October 16, 2023

**RE: 142 40<sup>th</sup> St. SW**  
**Grading and Drainage Plan**  
**Engineer's Stamp Date: 10/05/23**  
**Hydrology File: K12D037**

September 14, 2023

**RE: 142 40<sup>th</sup> St. SW**  
**Grading and Drainage Plan**  
**Engineer's Stamp Date: 09/05/23**  
**Hydrology File: K12D037**

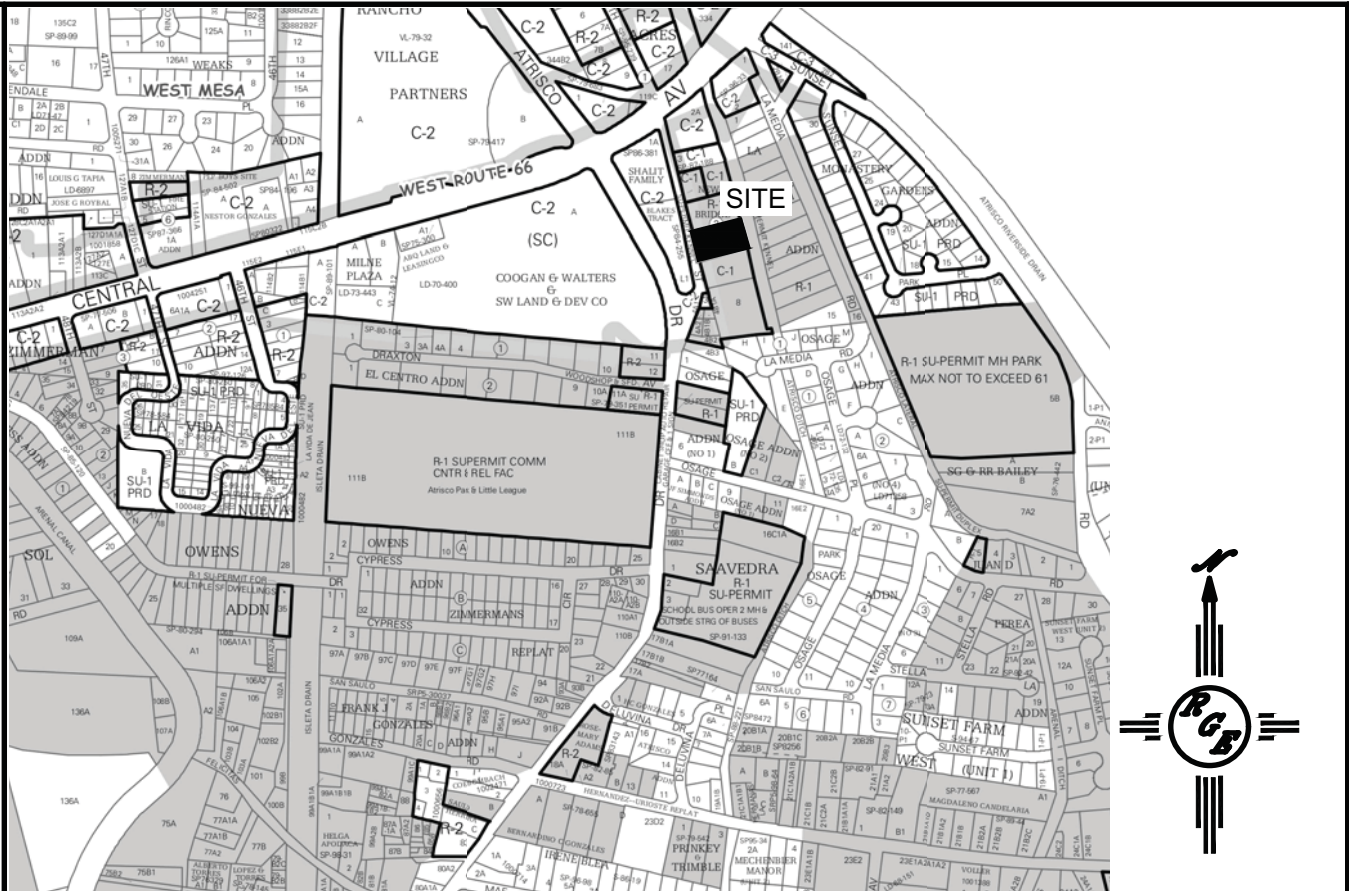
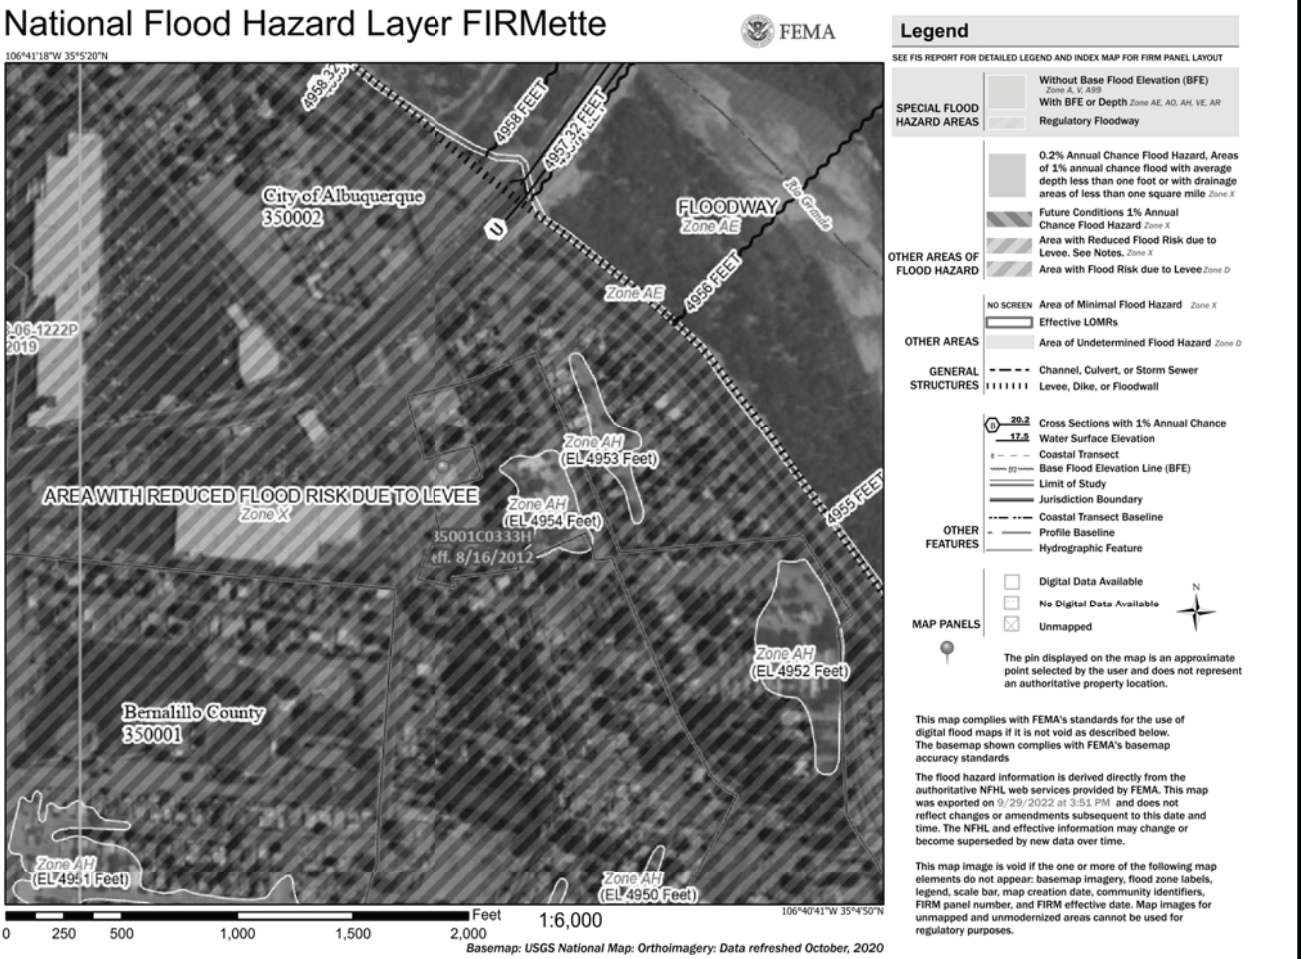
1. Please provide the stormwater quality calculation, multiply the impervious area by 0.26 inches for redevelopment sites. **CORRECTED**
2. please follow Article 6-5 Valley Drainage Criteria of the DPM. The following conditions must be applied to the site:

- a. The maximum percent impervious of the lot and the contributing area may not be greater than 45%. **REDUCED TO 44% BY REPLACING REAR WITH GRAVEL**

- b. Pad elevation shall be a minimum of one (1) foot above the 100 year 10-day stormwater surface elevation. **THIS IS COMMERCIAL, THE ADA PREVENTS US FROM RAISING PAD. THE LOT OVERFLOWS TO SURROUNDING AREA. THIS FUNCTIONS IN ACCORDANCE TO THE STANDARD**

- c. The flow between the front yard and back yard cannot be obstructed. The stormwater must be allowed to equalize to the same level between the front yard and back yard. **PROVIDED**

- d. A permanent perimeter wall or barrier around the development is required to contain the 100 year 24 hour storm developed runoff. **WALL DETAILS SHOW**

- e. The high point of the street should be four inches above the 100 year 10-day stormwater surface elevation. **THE SITE IS EXISTING AND HIGHER THAN THE SURROUNDING AREA**

- f. The retention pond is the 100 year 10-day volume and not the 100 year 24 hour volume. **CORRECTED**
